From: Martyn White
Sent: 11 March 2019 16:06
To: Daniel Vick
Cc: Planning.Responses
Subject: Comments from the Conservation Committee - AB/137/18/HH

AB/137/18/HH Victoria House, 47A King Street, Arundel
No objection

FLOOR PLANS AND DETAILING

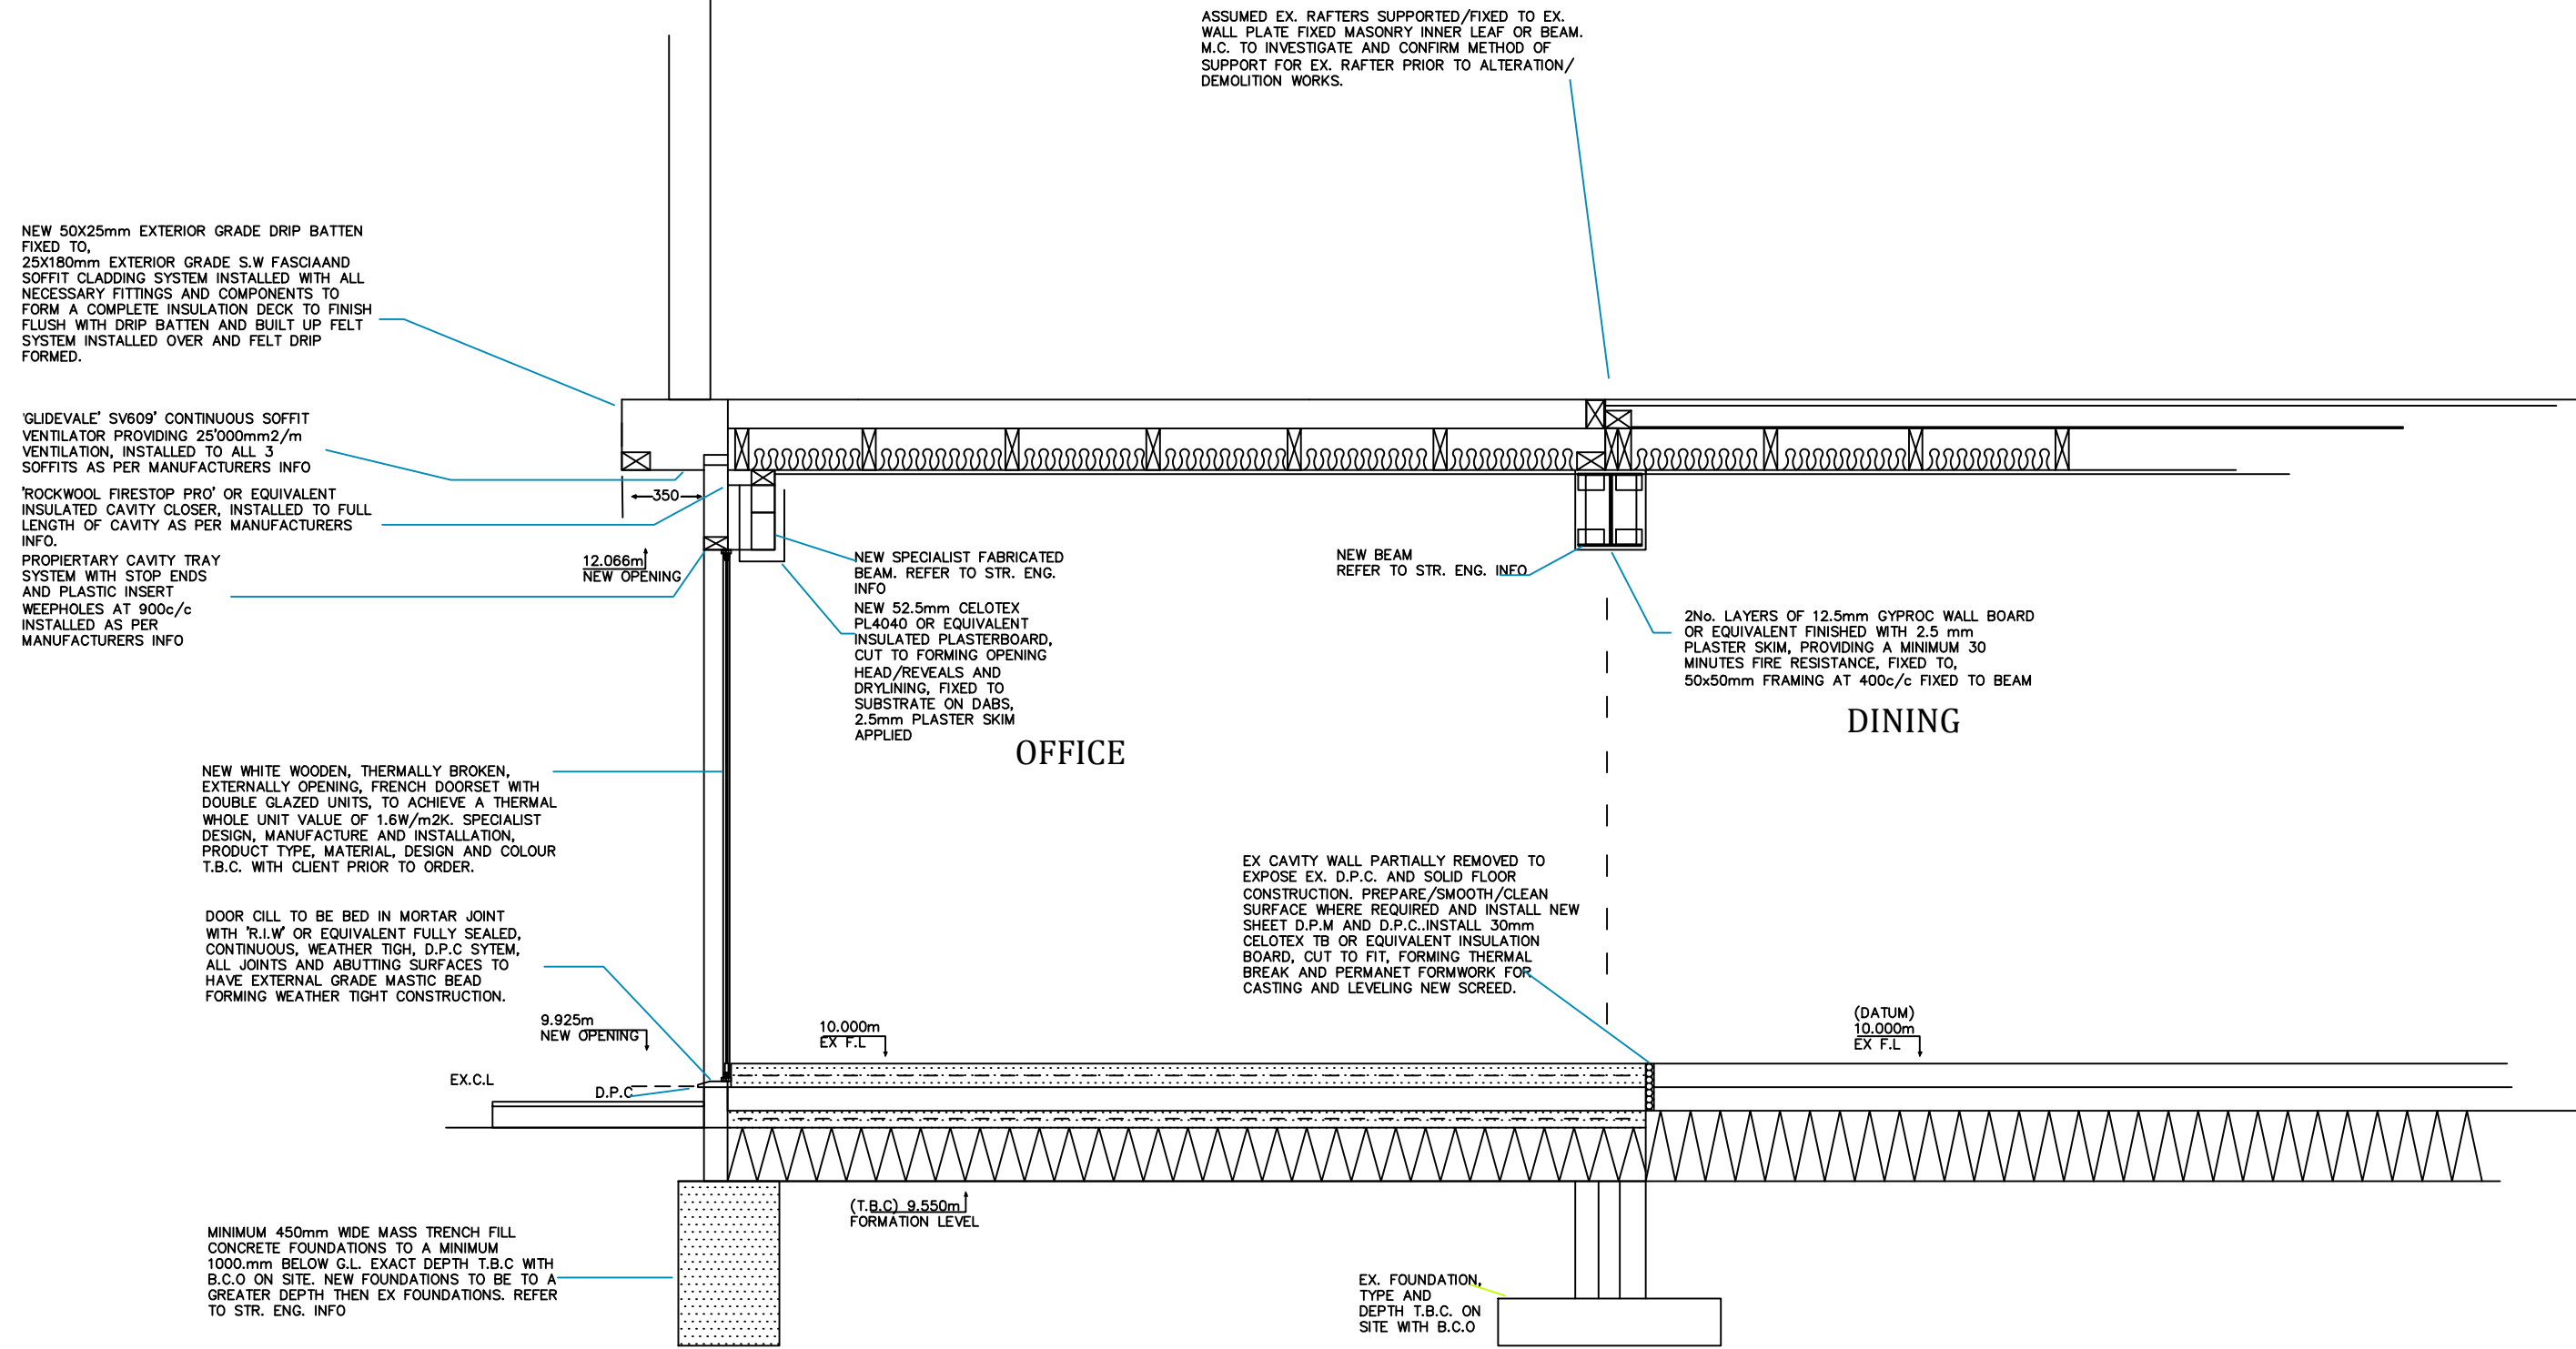
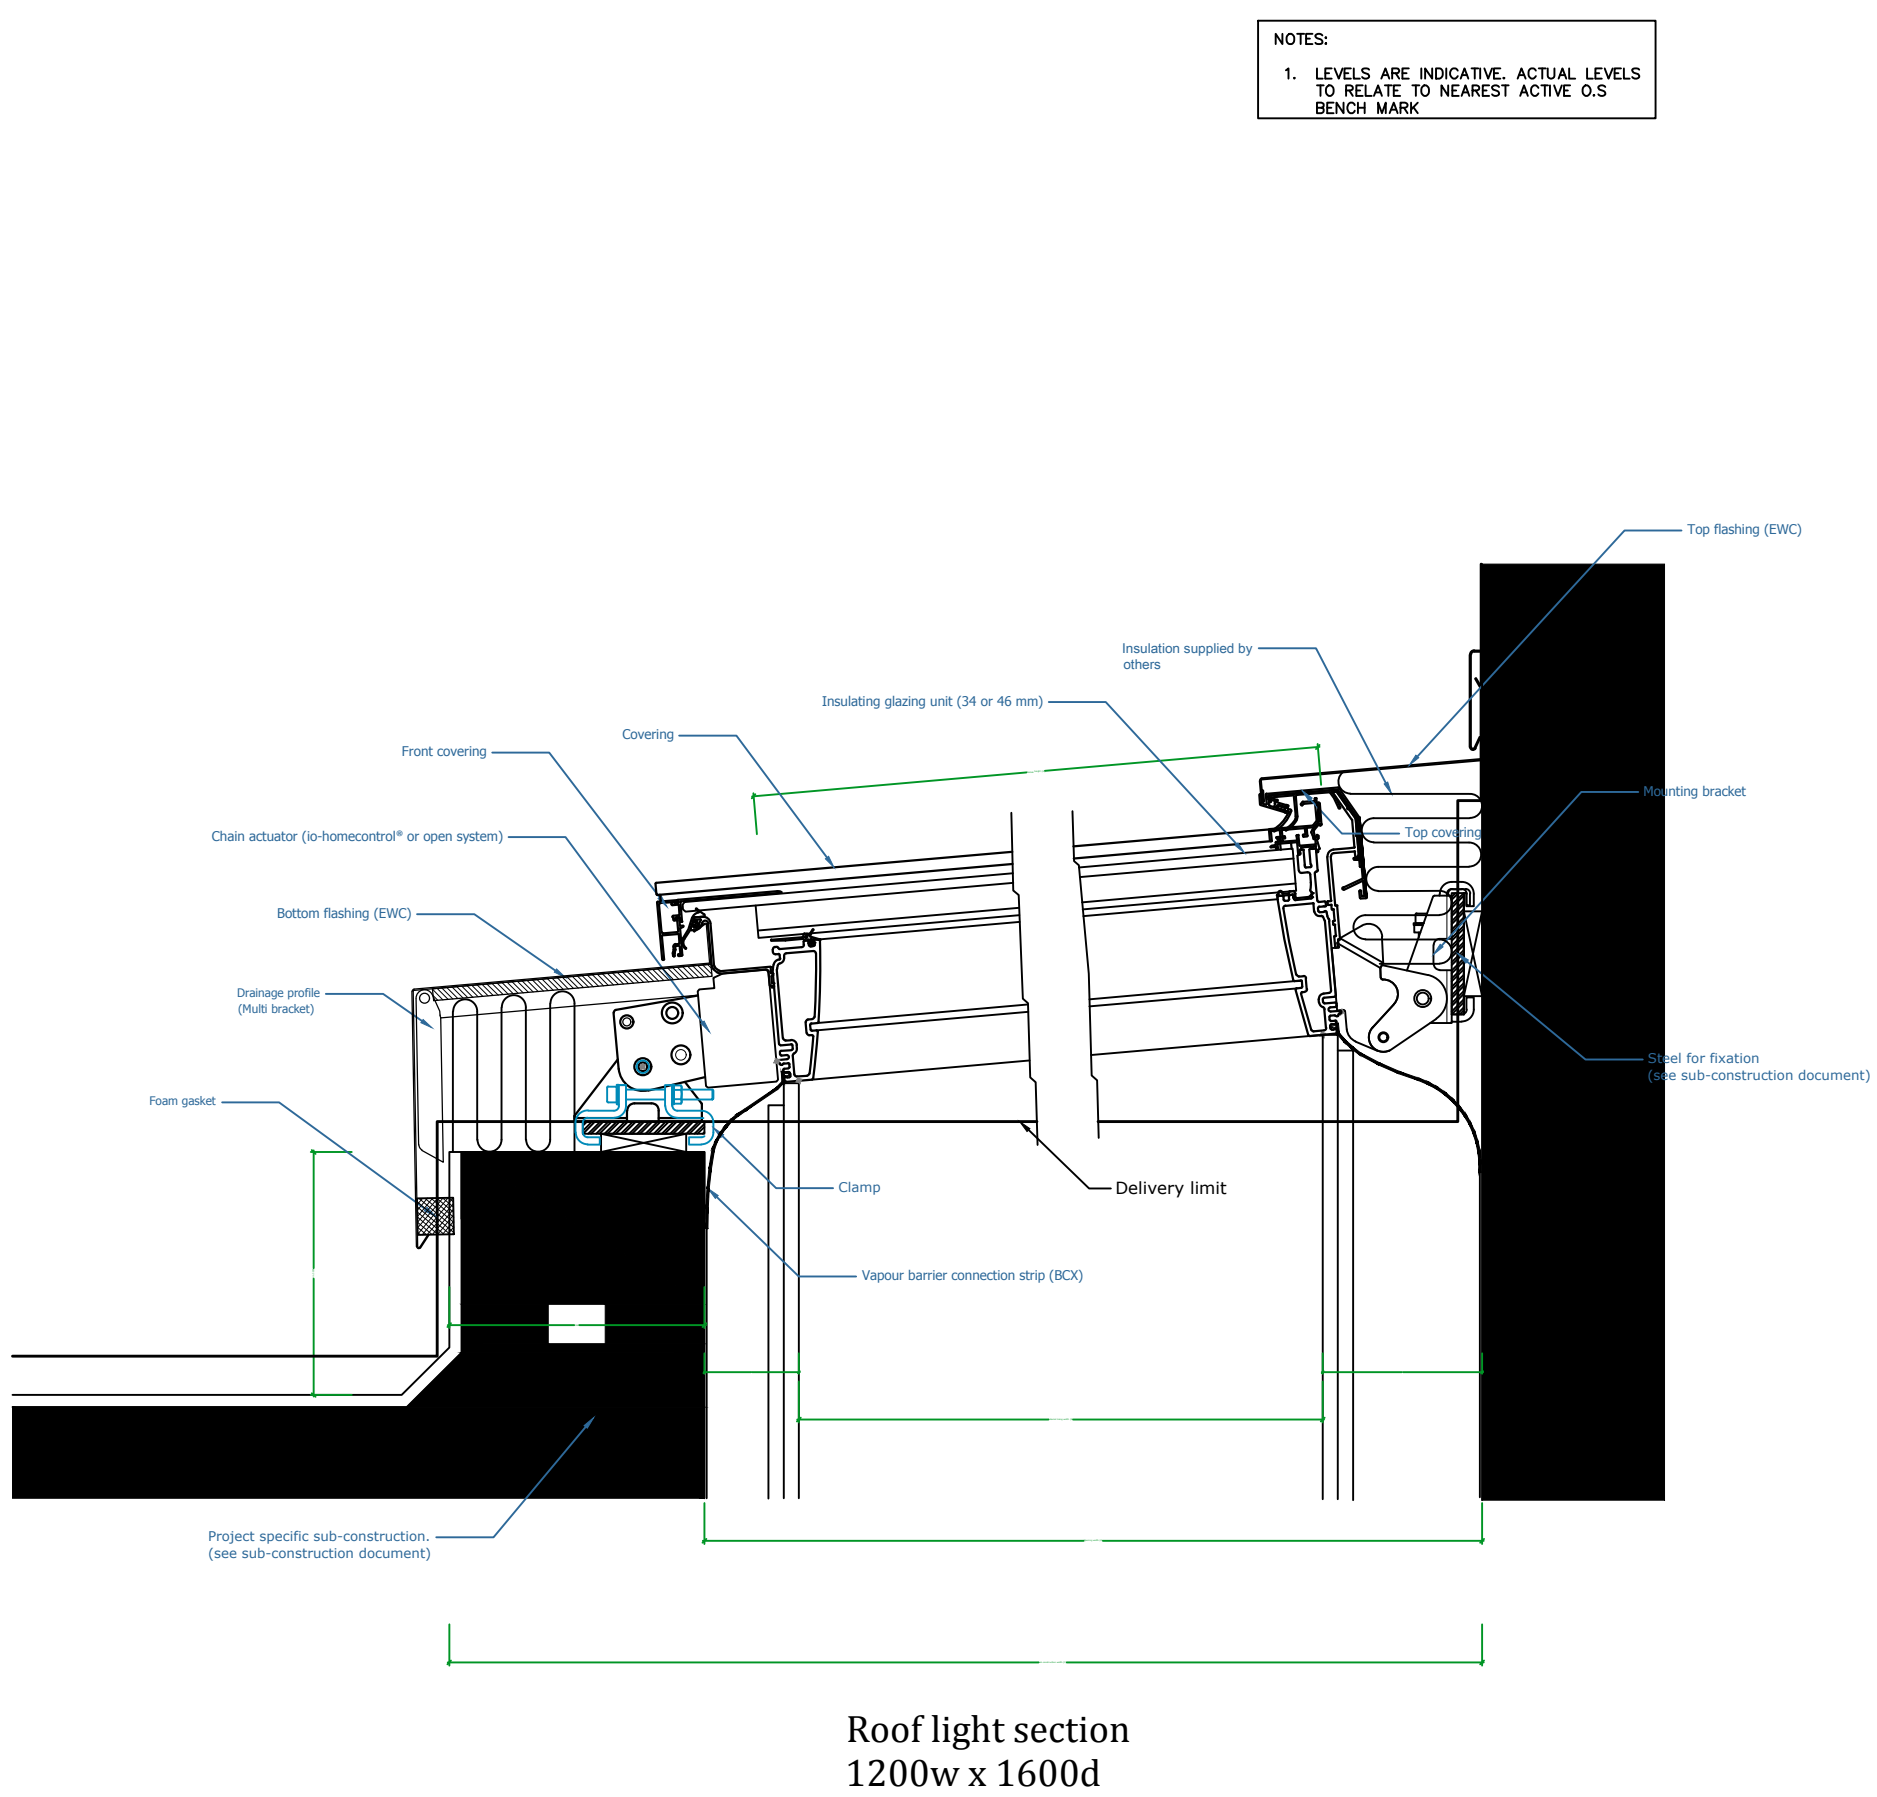
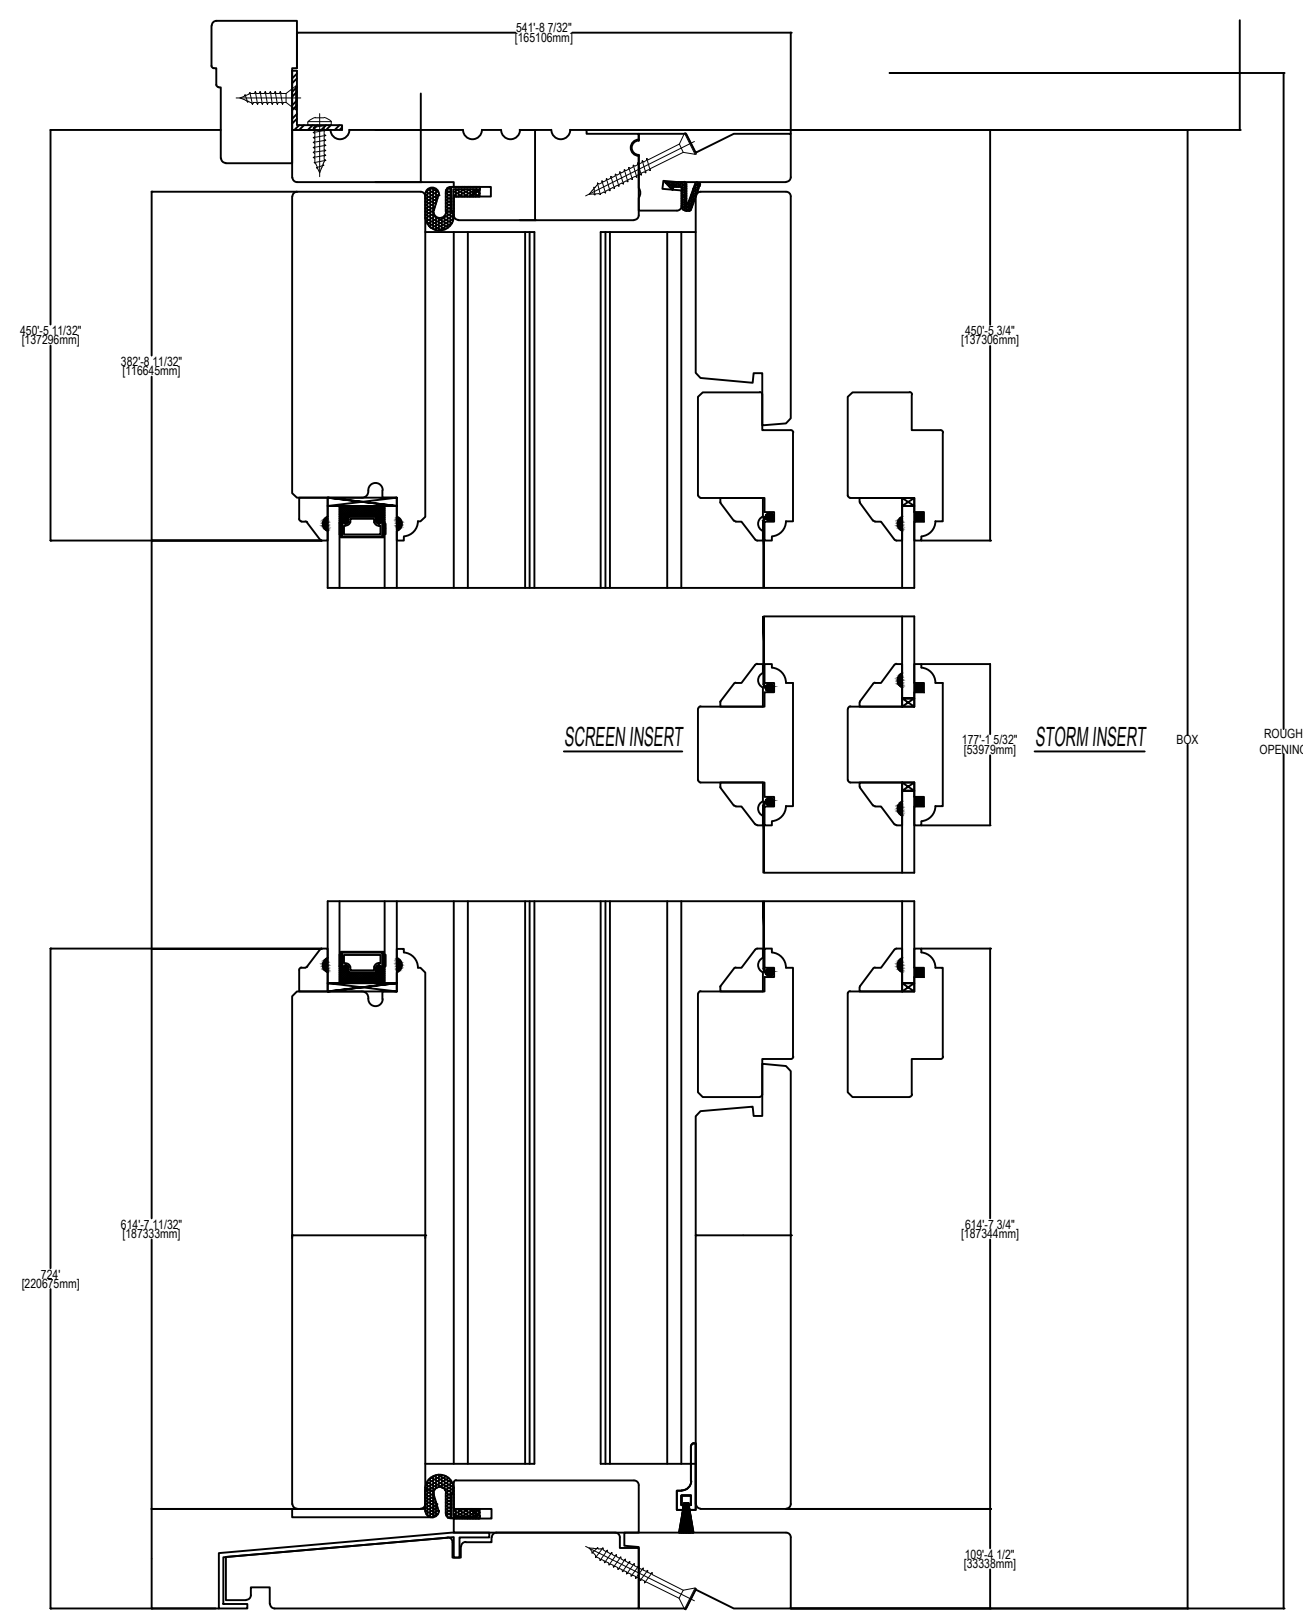
The south elevation does not appear to be correctly drawn with the rooflight in the wrong façade.

New double glazed window detail

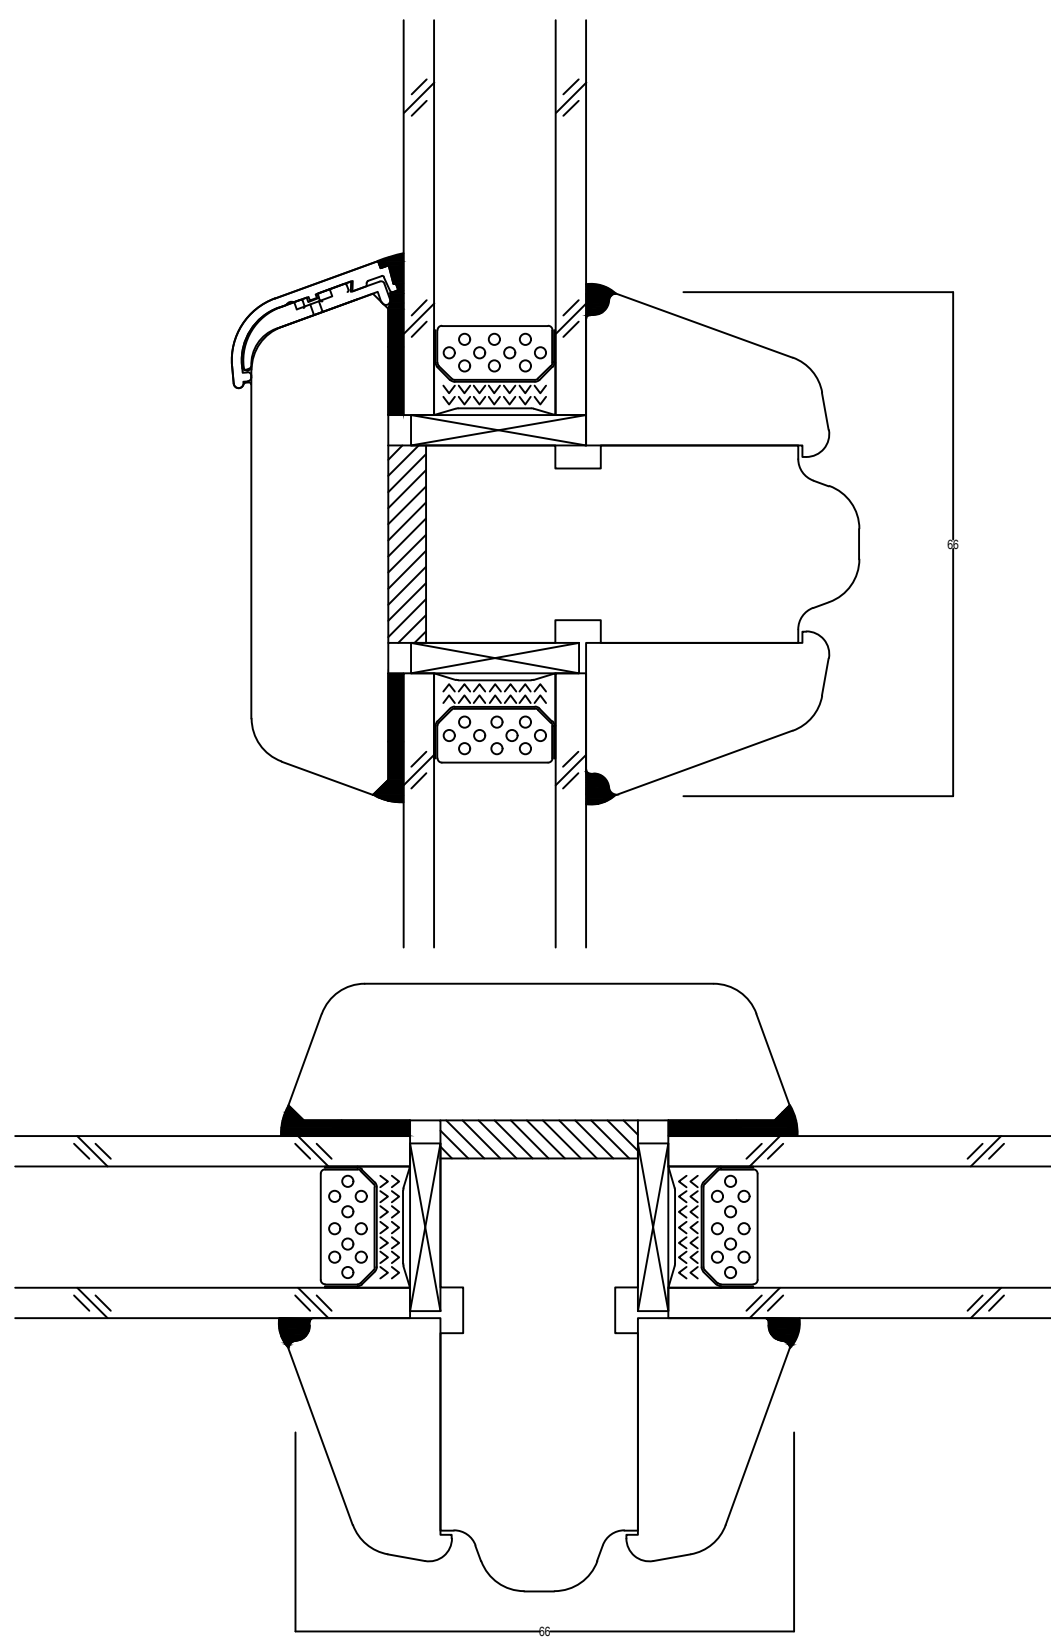
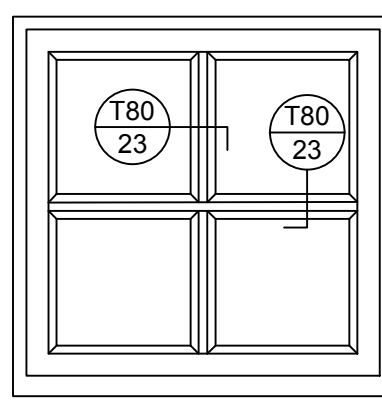
This building definitely falls within the criteria for local listing and it is an extremely important building in the street scene. Therefore, any new timber double glazed windows must match the existing ones in every detail. This may result in the windows having to be custom made. For information the building dates to circa 1900 and was designed by the Norfolk Estate. Precise details should be submitted to the Planning Officer
